**COLORADO**  
**Department of Transportation**  
Region 2  
Traffic & Safety - Access Permits

October 3, 2024

RE: PPR2422 - UDON RV Storage Plot Plan Review

FIGURE 17
 UDON REZONE
 EL PASO COUNTY, COLORADO
 2026 RECOMMENDED GEOMETRY &
 CONTROL – PHASE 1

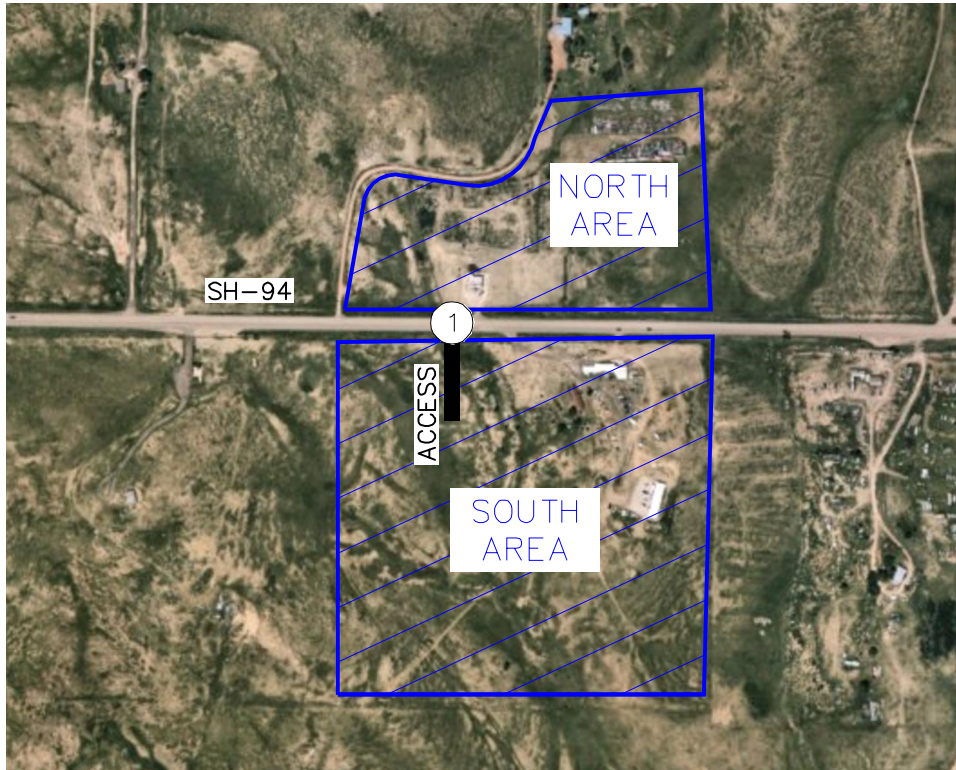
- The access will initially be a T-intersection with only the south area developing in Phase 1.
- Three CDOT Access Permit Applications have been received and are being processed.

FIGURE 18
 UDON REZONE
 EL PASO COUNTY, COLORADO
 2028 RECOMMENDED GEOMETRY &
 CONTROL – PROPOSED BUILDOUT

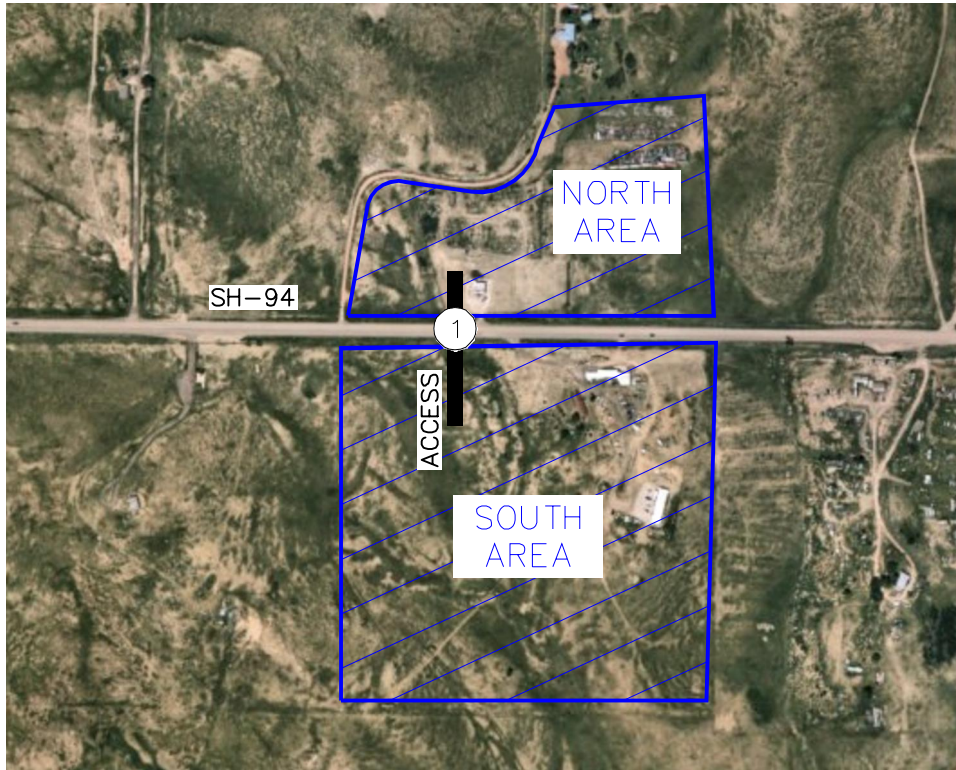
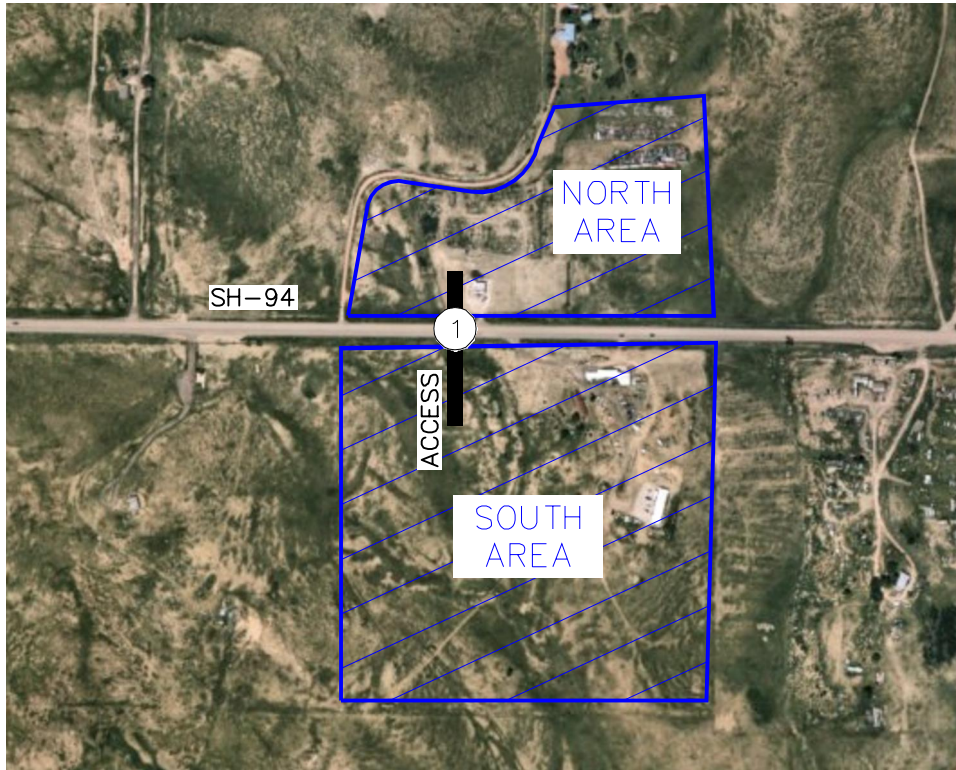
- Given that this application is for a rezone to commercial use, CDOT Traffic anticipates that at full build out the access will warrant auxiliary lanes and an intersection control analysis. CDOT Traffic agrees that no improvements for the storage units are warranted.
- As development continues, additional review from CDOT is required.
